Application for a Non-Material Amendment Following a Grant of Planning Permission

Erection of an extension to the first floor above the existing garage, erection of extension to front and construction of an outbuilding

21/01829/PLF

Drawing No: **21 48 500A**    Scale: 1:100 @ A1

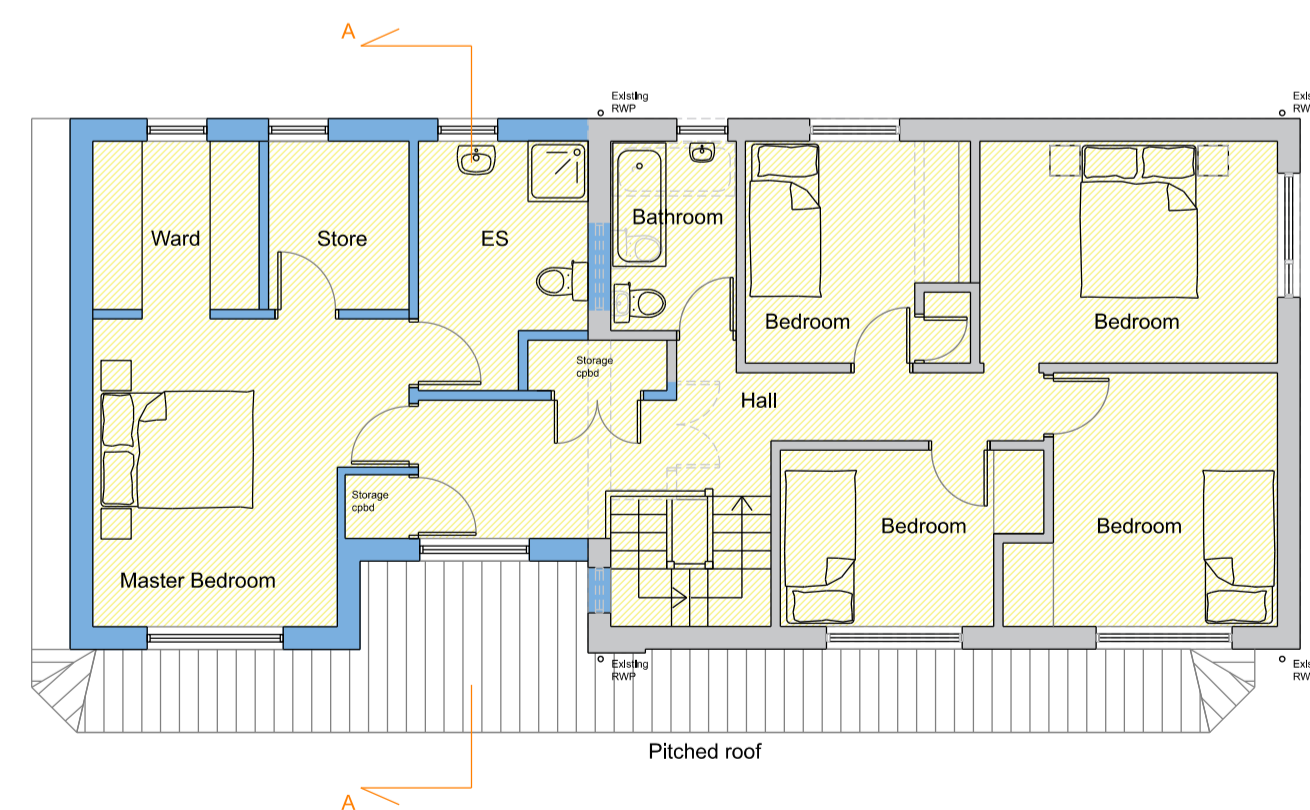
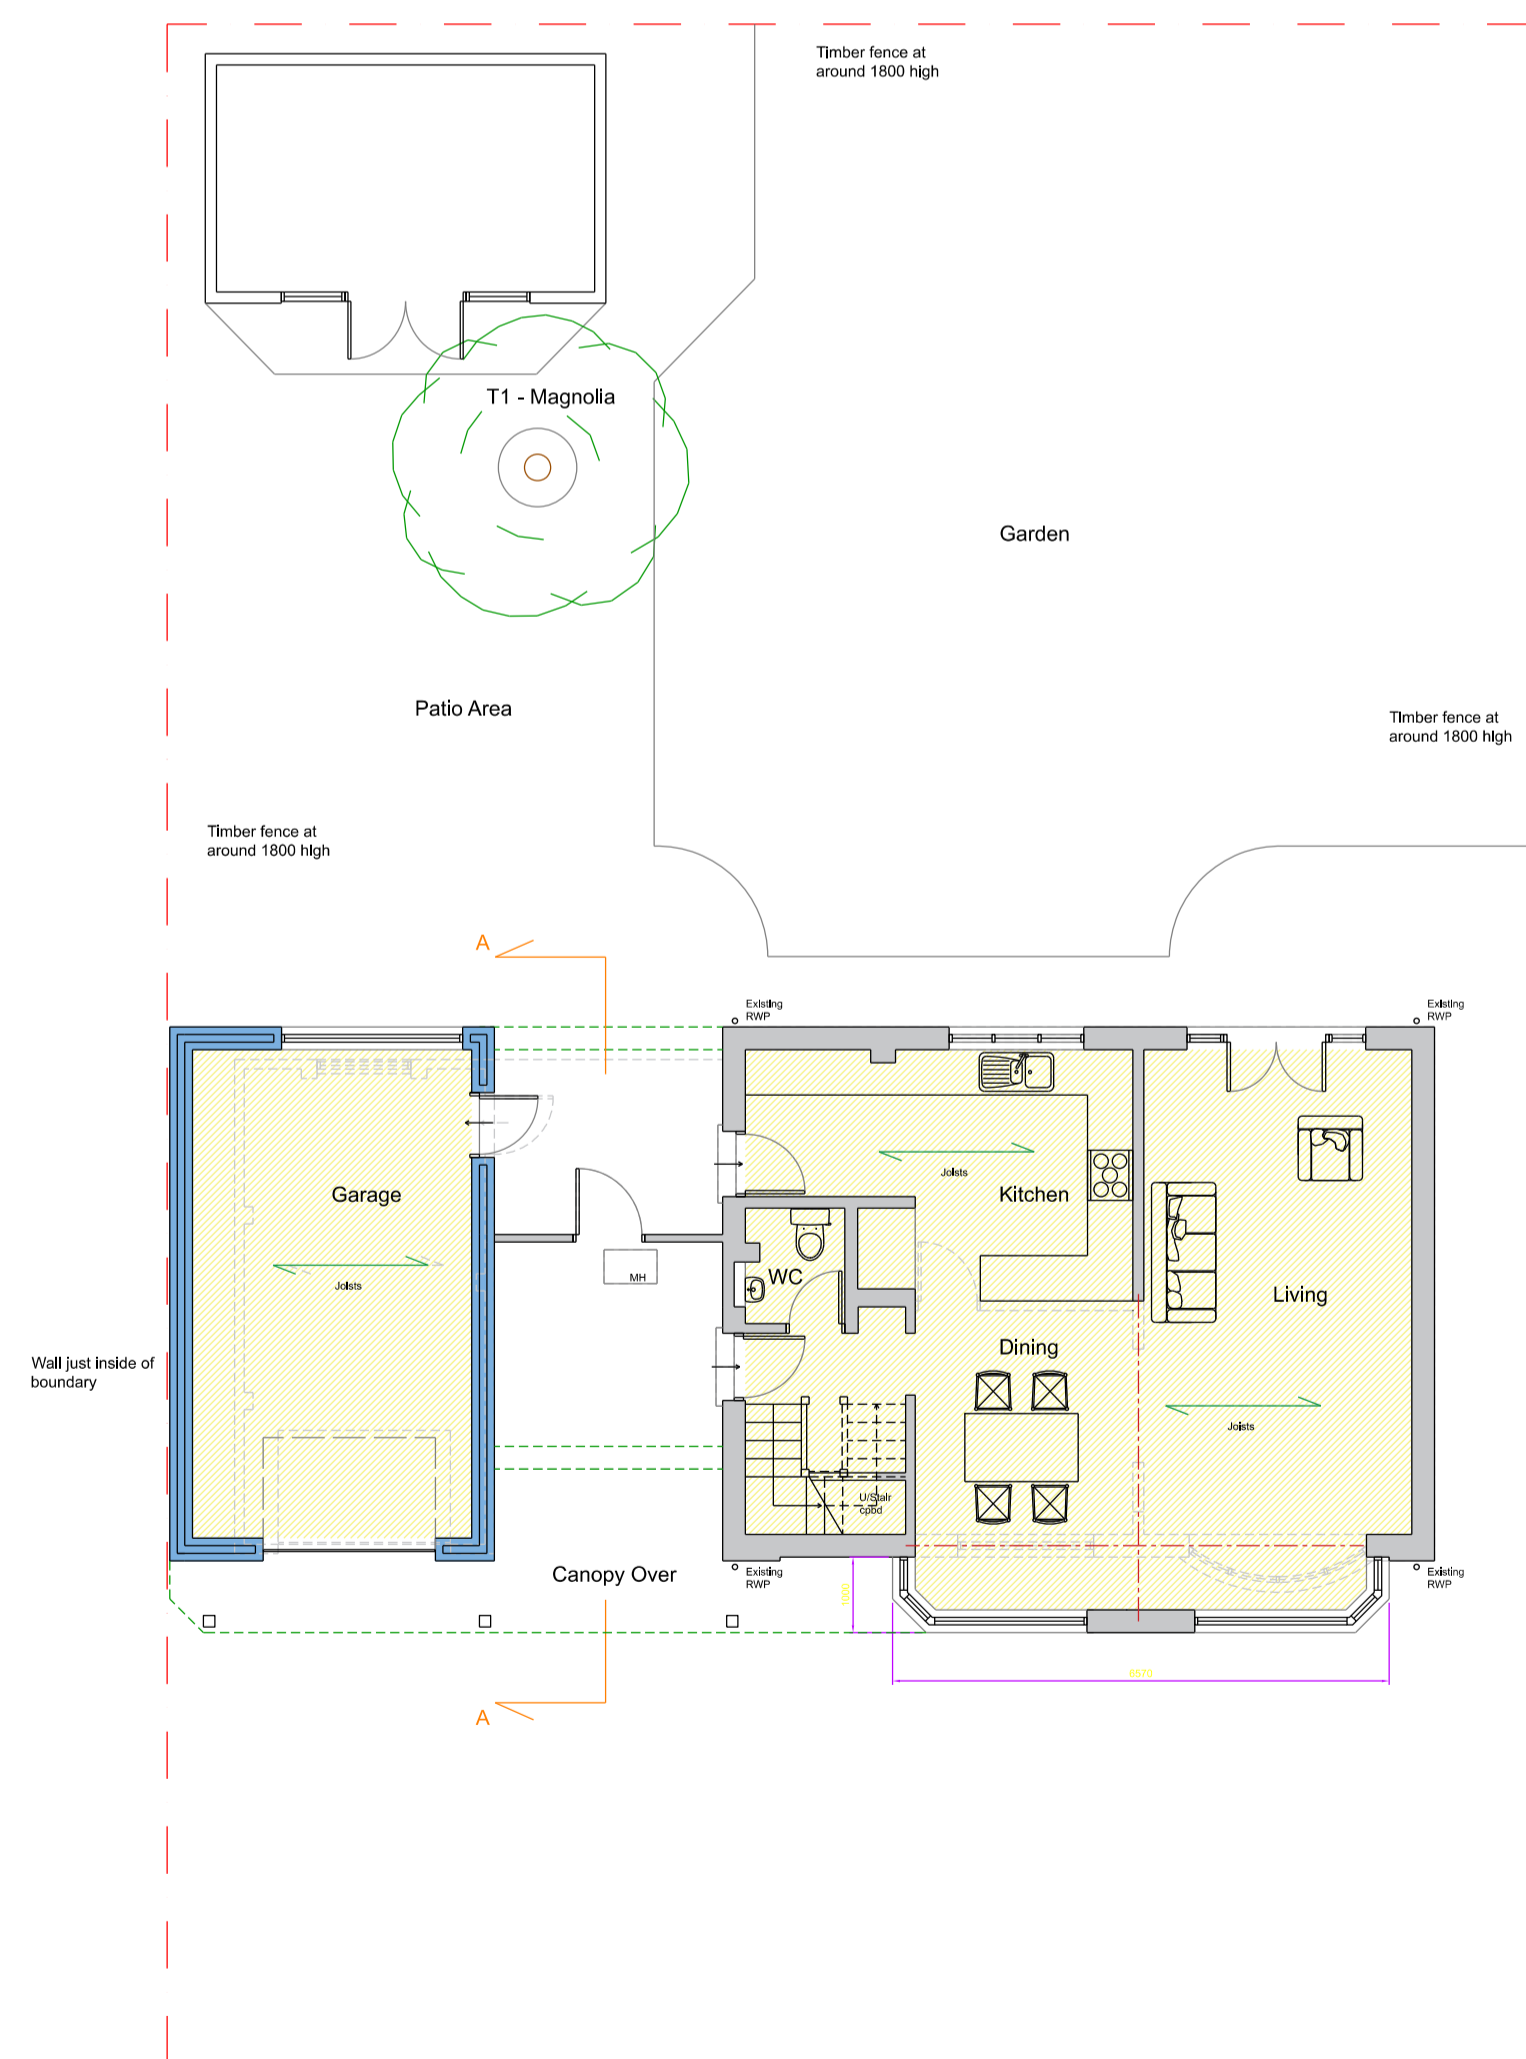
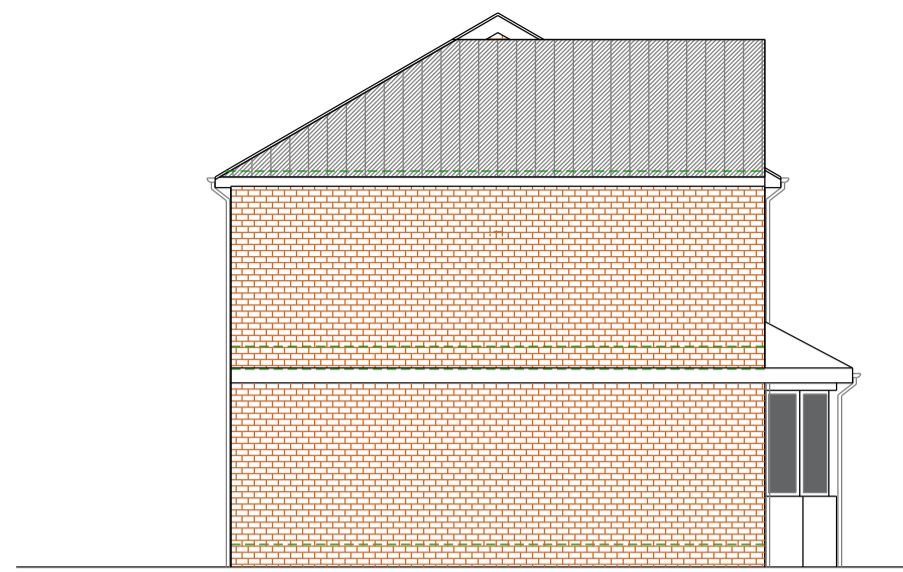
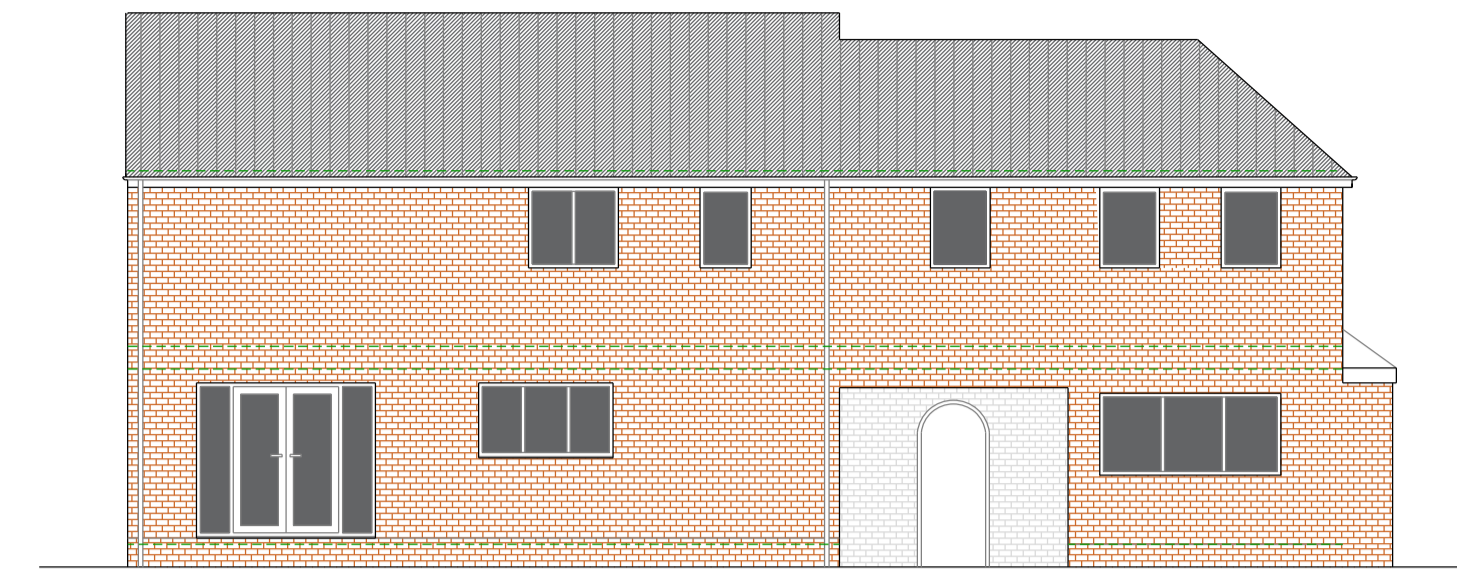
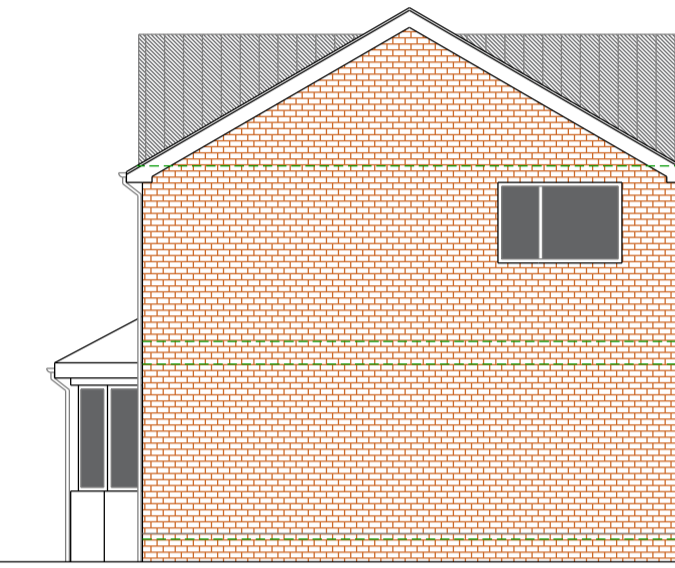
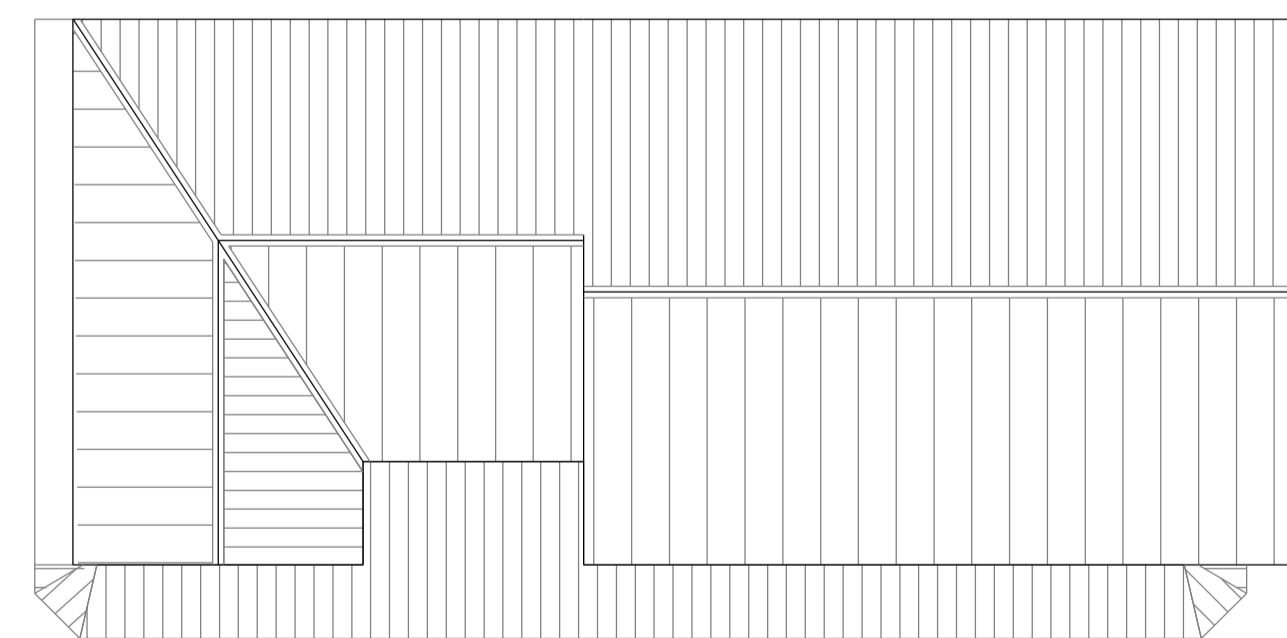
Minor amendment to garage - made 600mm bigger at ground floor level. Minor amendments to first floor windows and roof. Canopy added to front.
